RDC 08M635 vol 4&5
MP08_0257 & MP08_0258
Edmond Platon
8849 2906

**SYDNEY
REGIONAL
DEVELOPMENT
ADVISORY
COMMITTEE**

**PROPOSED RESIDENTIAL DEVELOPMENT AT 61 MOBBS LANE, EPPING
STAGE 1- RESIDENTIAL DEVELOPMENT (MP08_0257) AND
EARLY WORKS PROJECT (MP08_0258)**

**CHANNEL 7 - MOBBS LANE UPGRADE  
INTERSECTION WITH MIDSON ROAD**

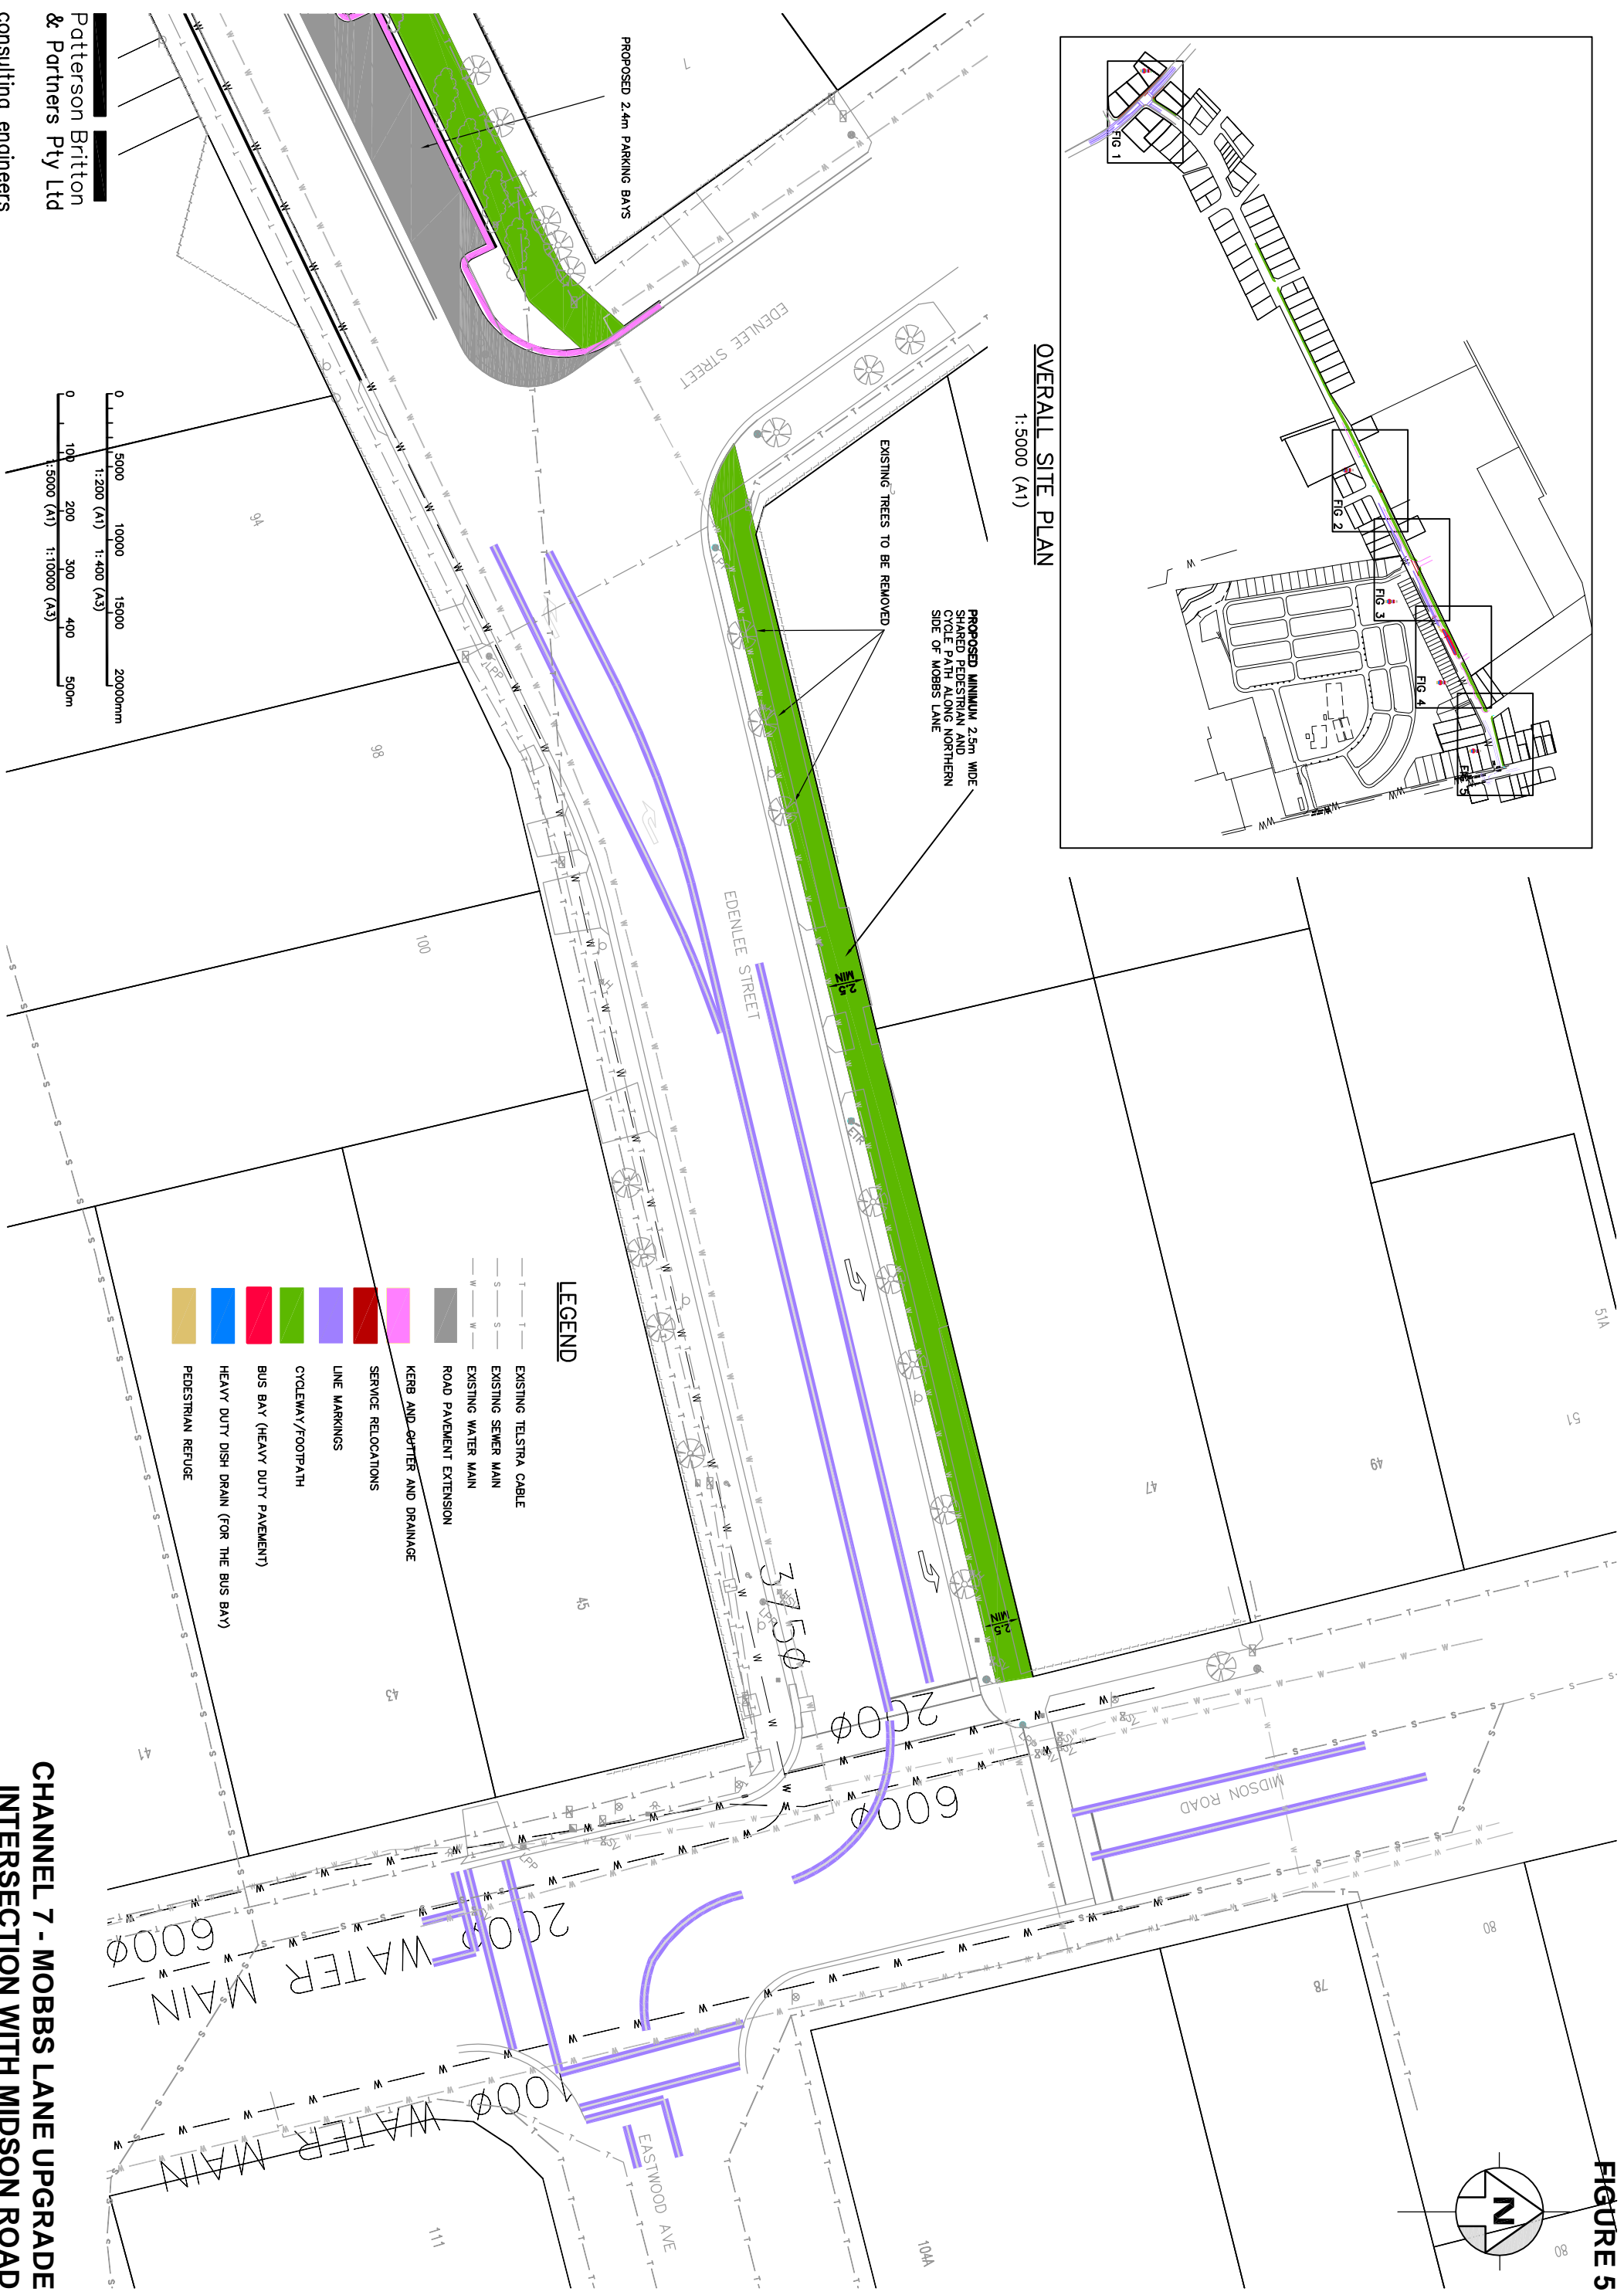
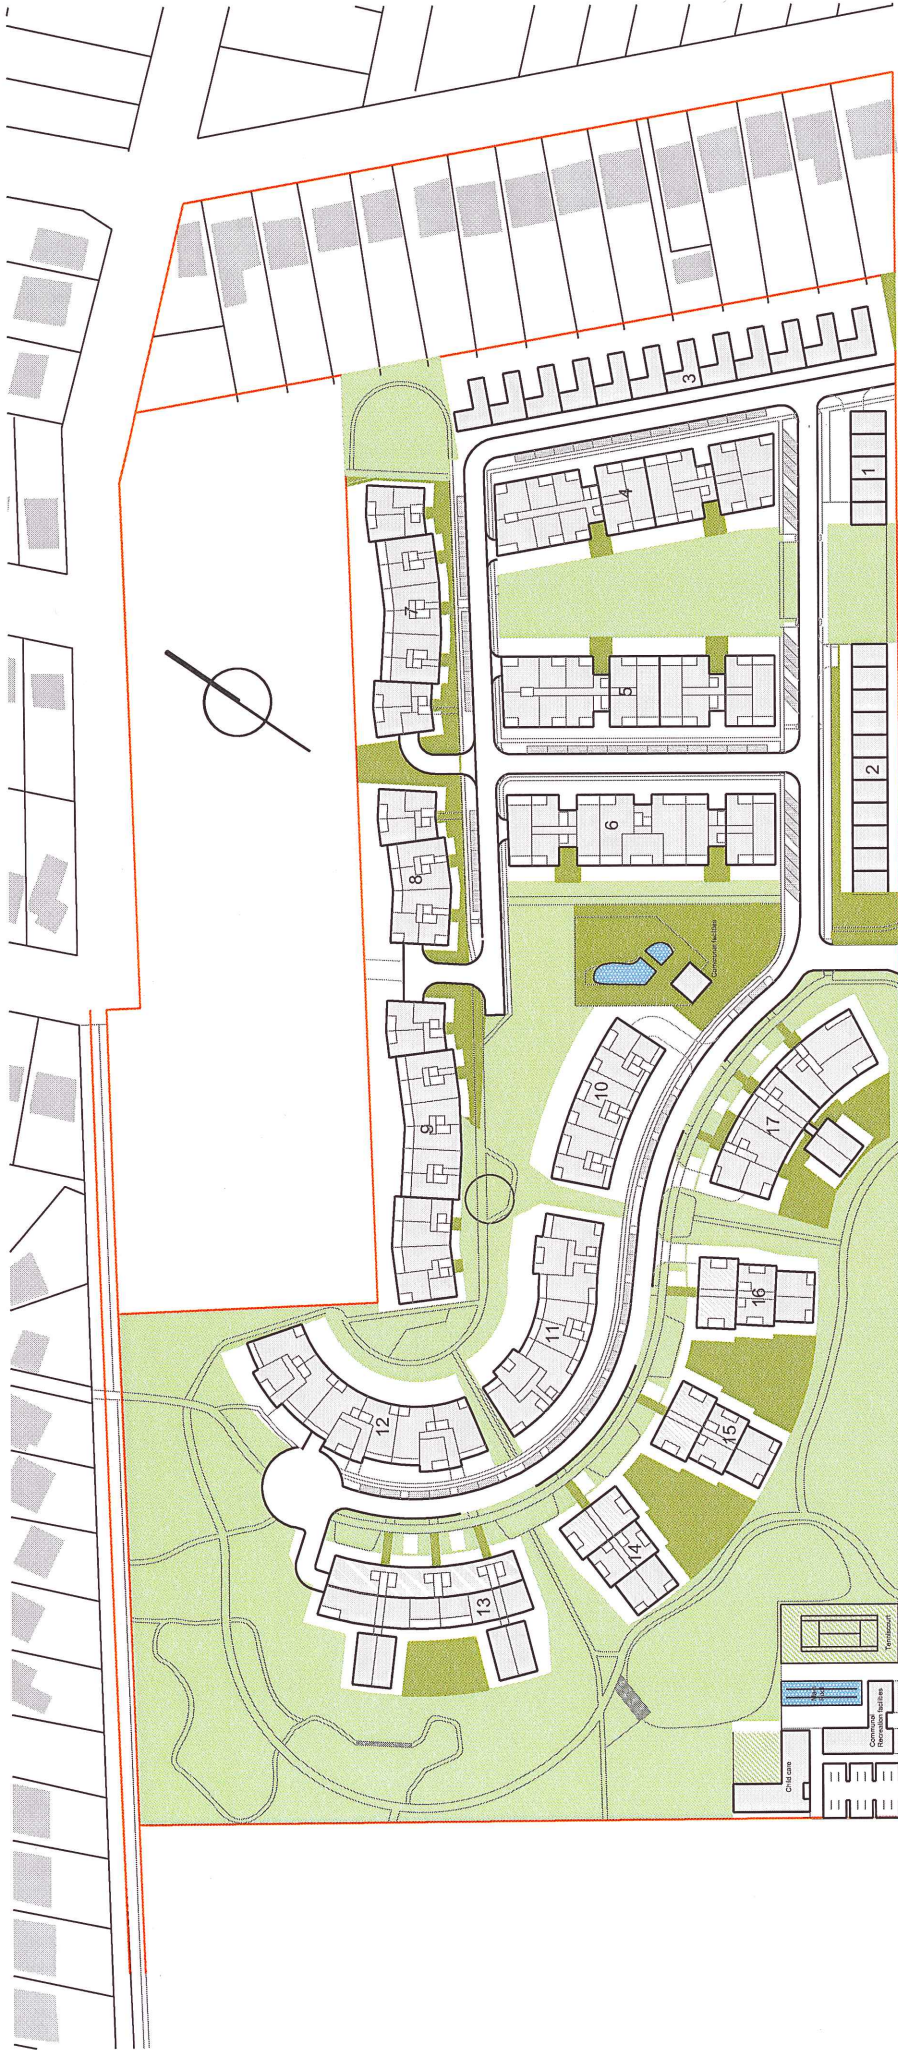
4. The developer must pay the full 10 year traffic signal operation maintenance cost.
5. With regards to the timing for the works proposed at the signalised intersection of Mobbs Lane/Midson Road, considering there could be parents that would walk to the child care centre from Midson Road, the proposed works shall be completed and fully operational prior to the release of the Occupation Certificates by the Certifying authority for both the Early Works Package or Stage 1 Residential Development, which ever is completed earlier.

6. Certified copies of the civil/traffic signal design plans at the Mobbs Lane/Midson Road intersection shall be submitted to the RTA for consideration and approval prior to the release of any Construction Certificate by the Certifying authority and commencement of road/signal works for both the Early Works Project and Stage 1 Residential Development.
